**Land south of Ford Lane and East of North End Road, Yapton
Application for Non-Material Amendment**

Please accept this letter and enclosures as an application for a Non-Material amendment under the Town and Country Planning Act 1990, Section 96A relating to materials approved under condition 1 of Reserved Matters consent Y/82/20/RES at Land south of Ford Lane and east of North End Road, Yapton.

Title:
MATERIALS PLAN

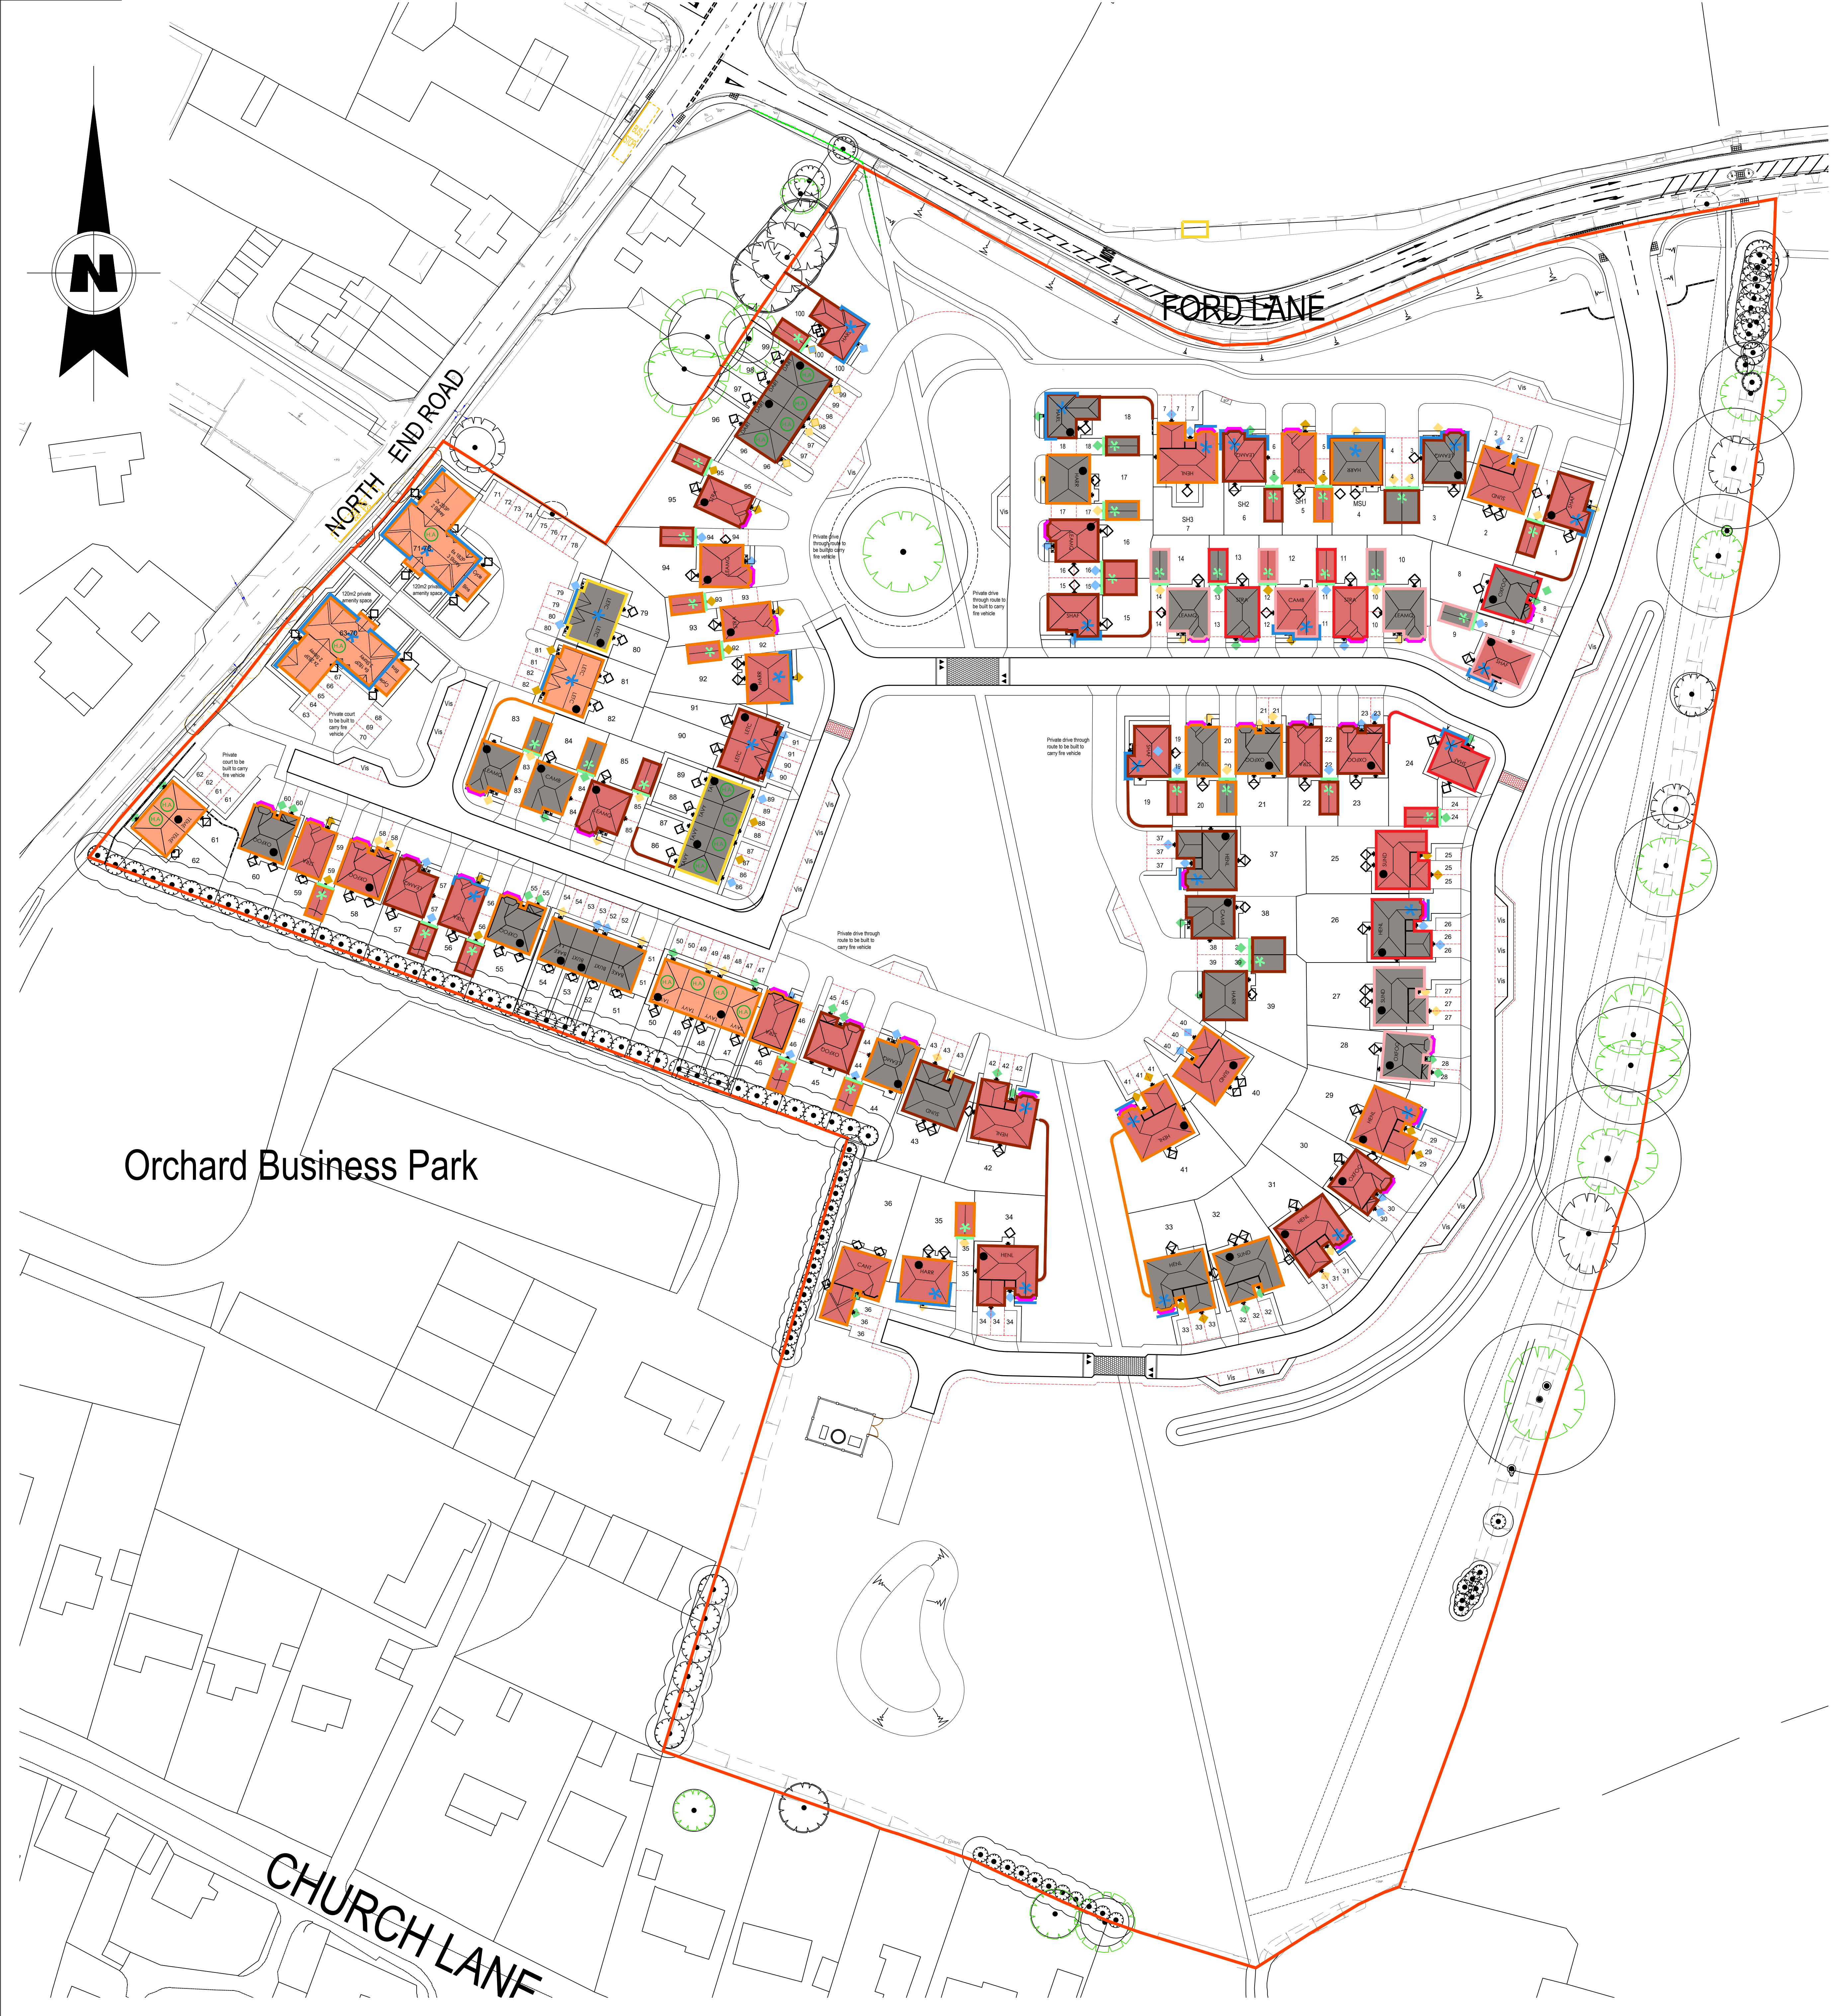
Condition 1 of the Reserved Matters consent lists the approved materials plan for the site. Due to issues with the manufacturing of the approved brick type, this application seeks to amend the approved bricks relating to plots 8-14 & 24-28 only.

The application proposes to replace the approved Capital Multi to New Cavendish and the Thakeham to Weston Reds for plots 8-14 & 24-28. The images below show how minor change in appearance between the approved and replacement bricks.

An amended Materials Plan (A855 72C) has been submitted with this application to reflect these changes.
